Our Ref: TR010031

Application by Highways England for an Order Granting Development Consent for the A1 Birtley to Coal House.

Advice following issue of decision to accept the application for examination

HE551462-WSP-LLO-ZZ-X-DR-GI-5003

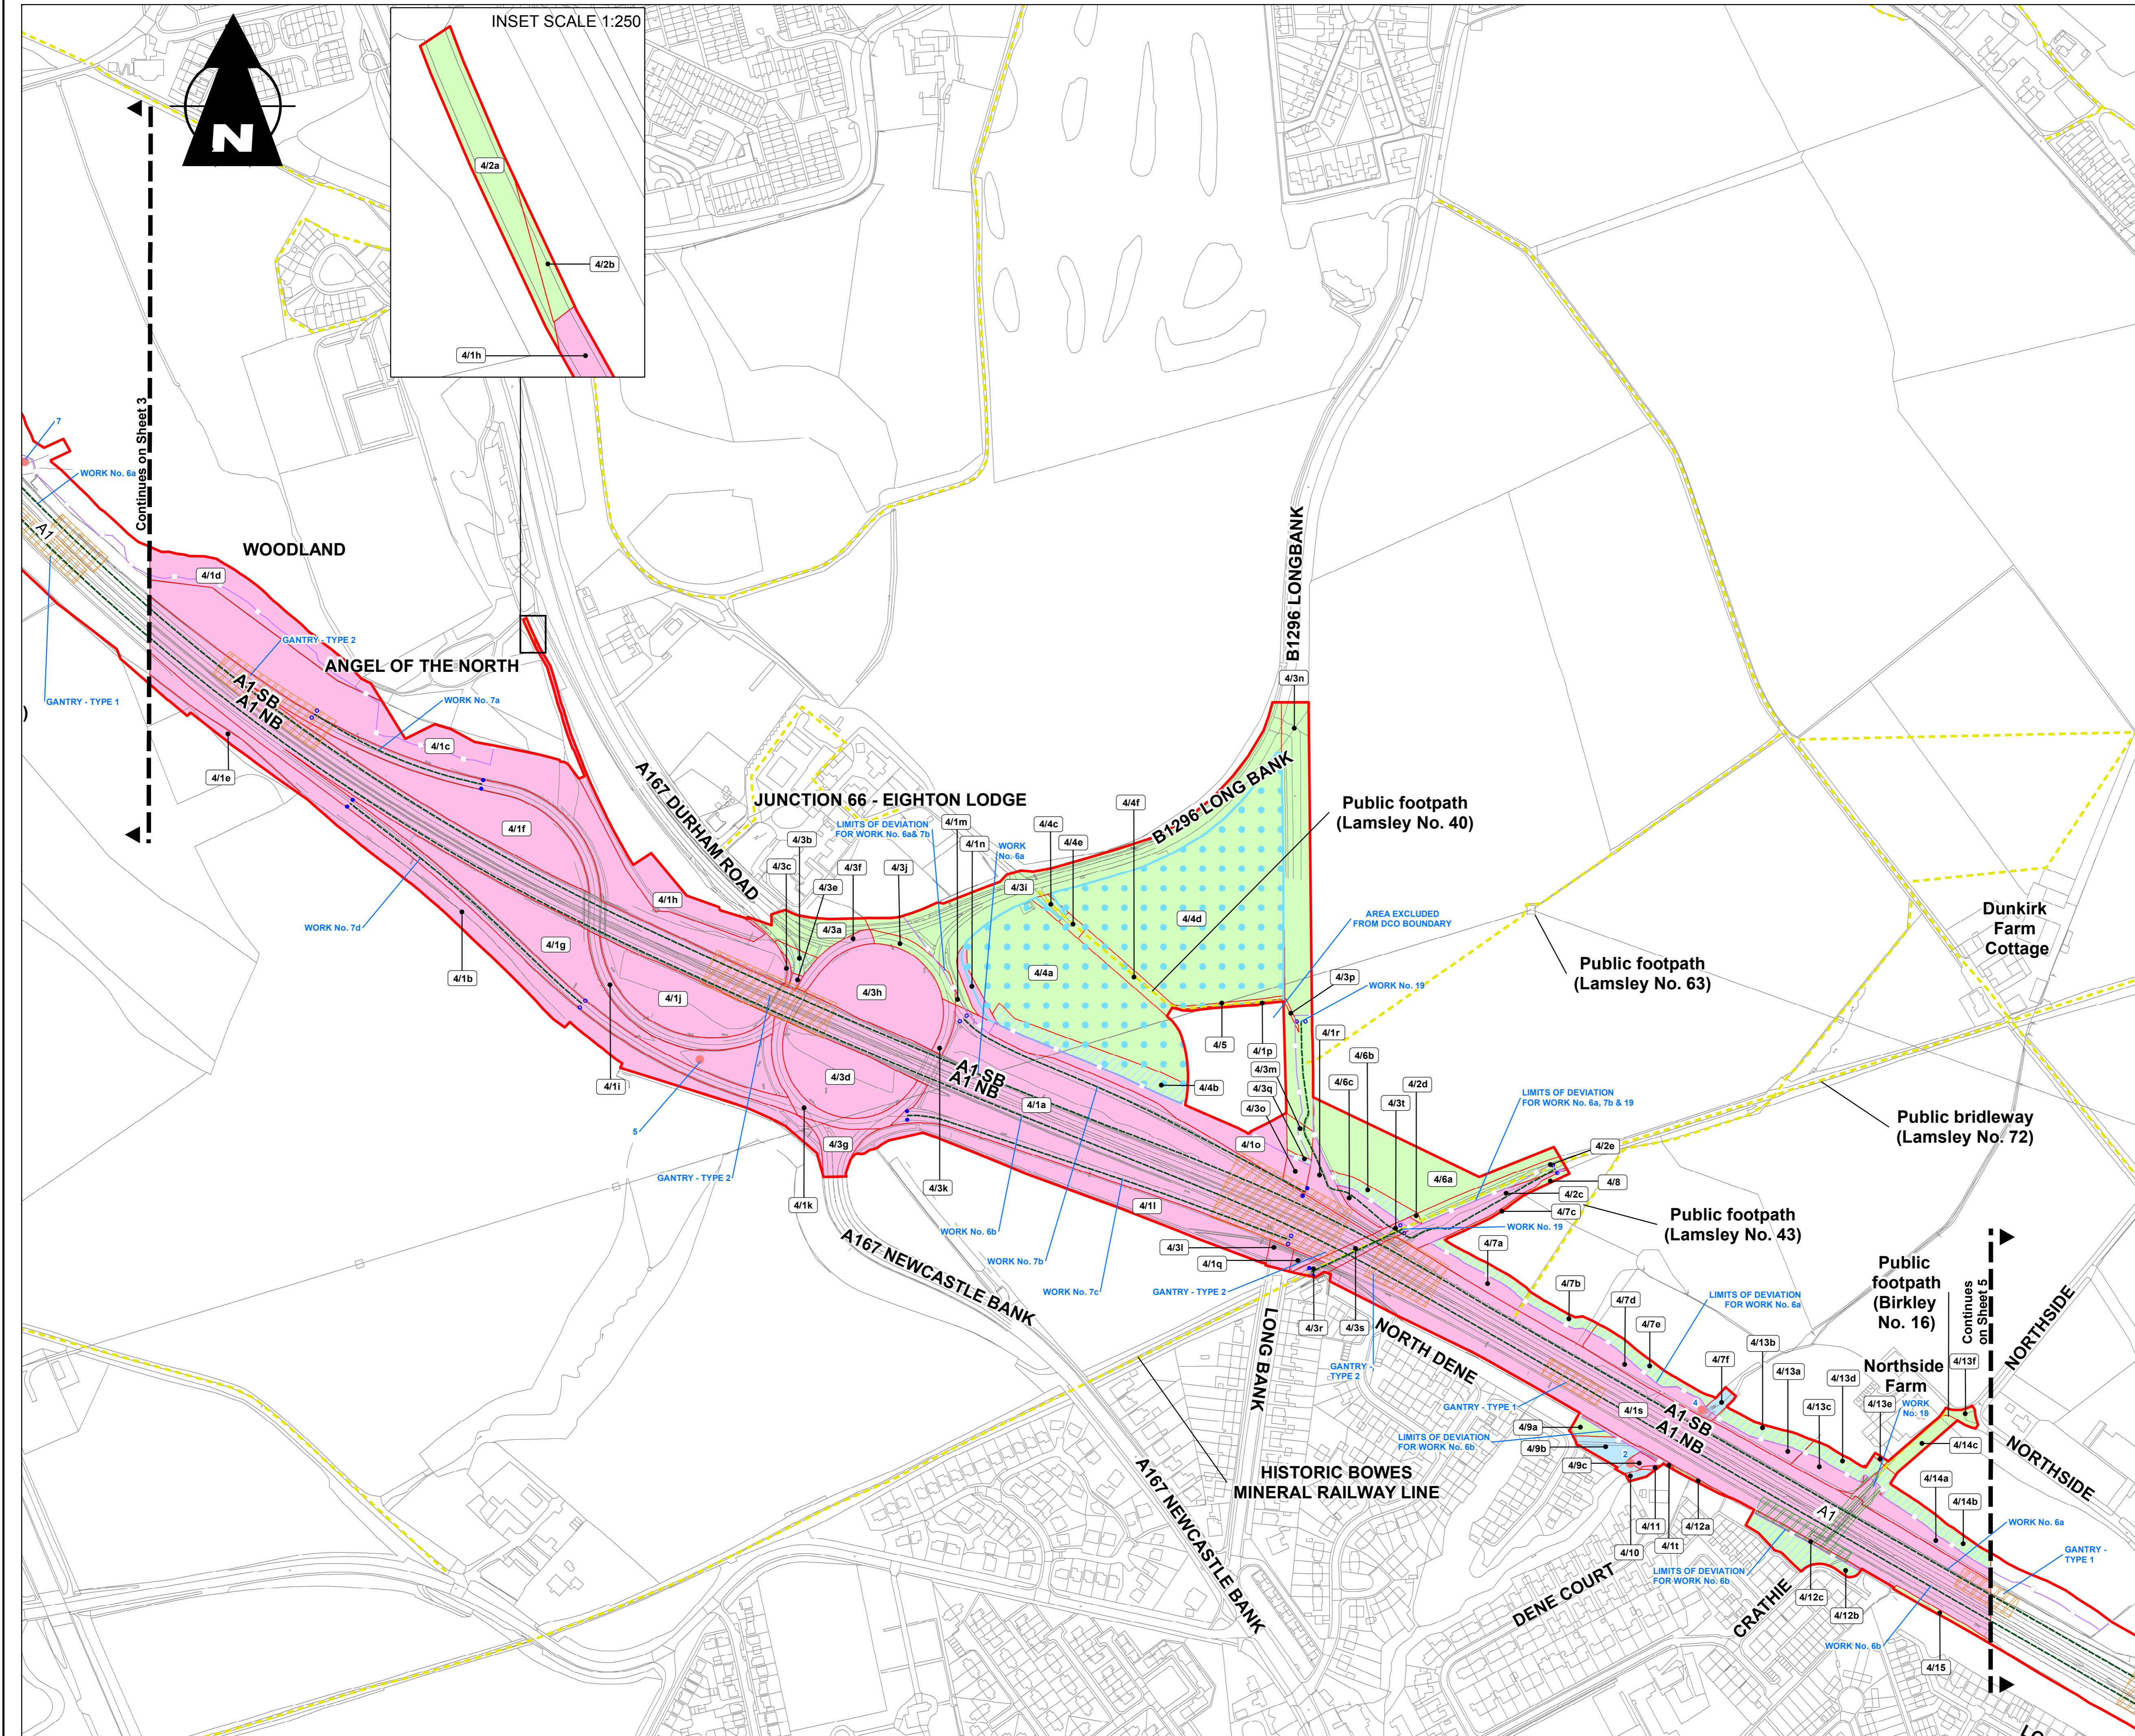
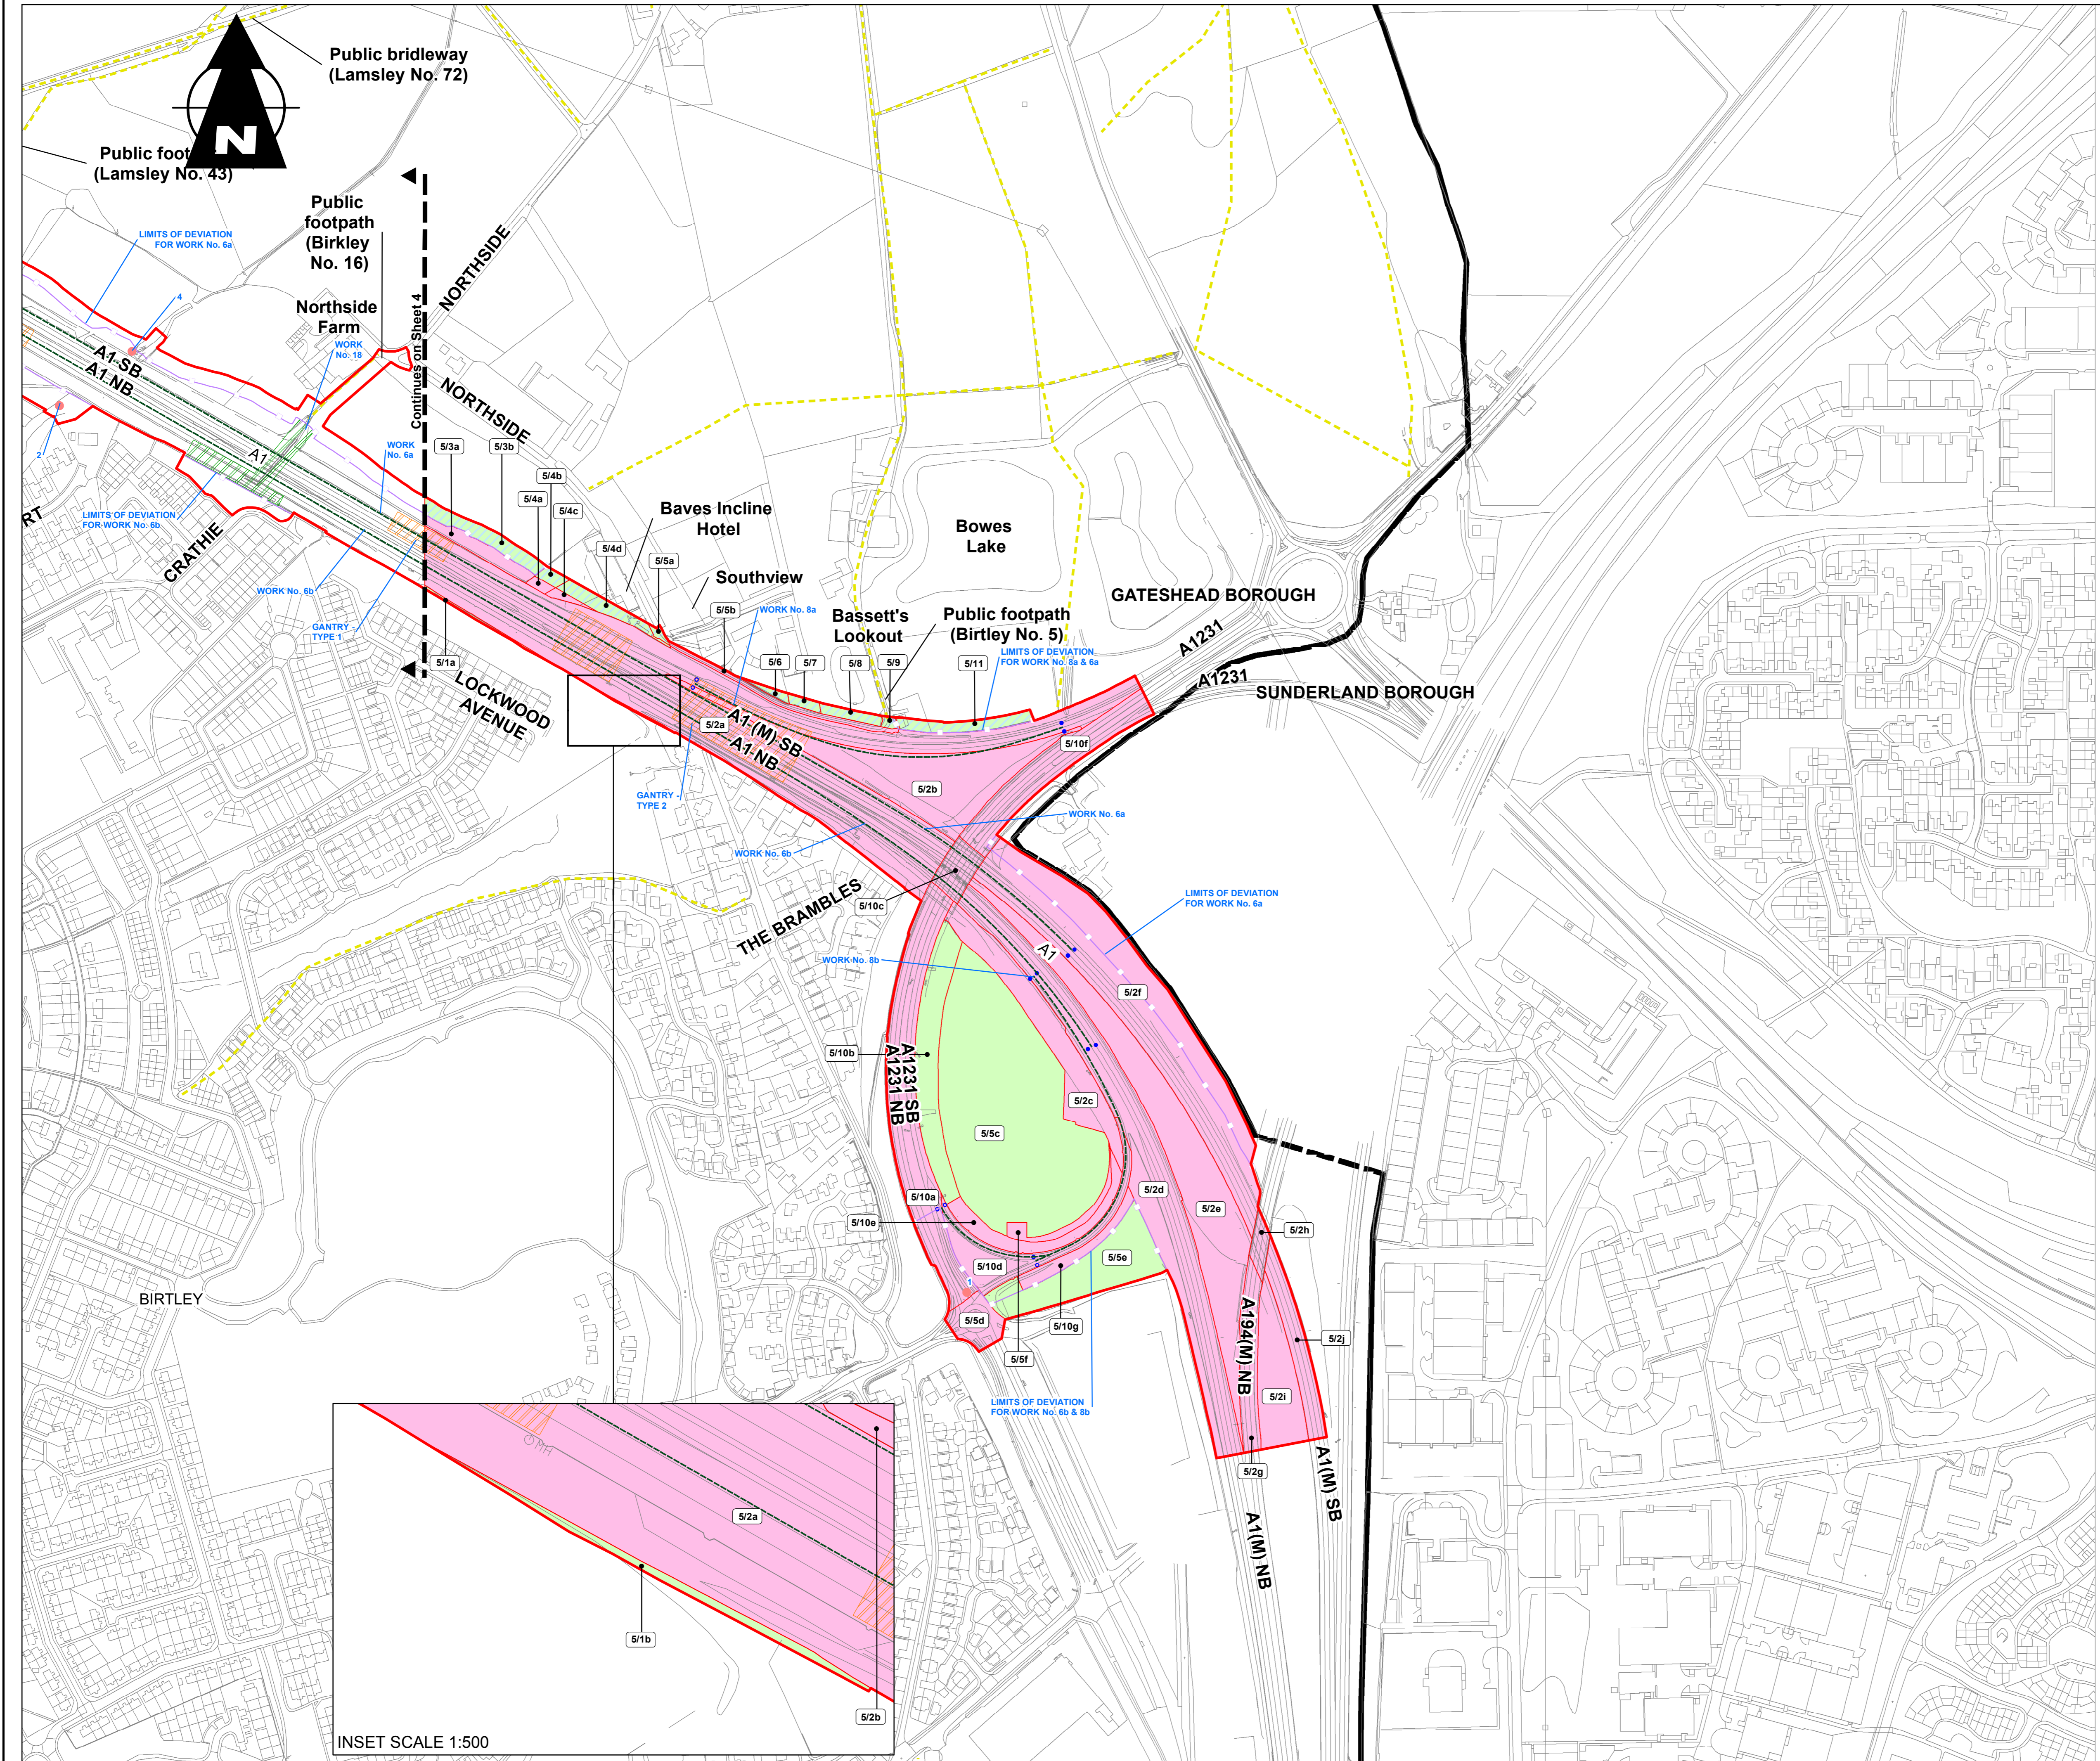
Upon review of the Statement of Reasons and Tables 1 to 6 (Annex A), PINS review of the Works described within these tables and a comparison with the Works and Lands Plan, there appear to be some discrepancies and it would be helpful, if the Applicant could provide a plan or set of plans to show clearly the land plots in relation to the Works.
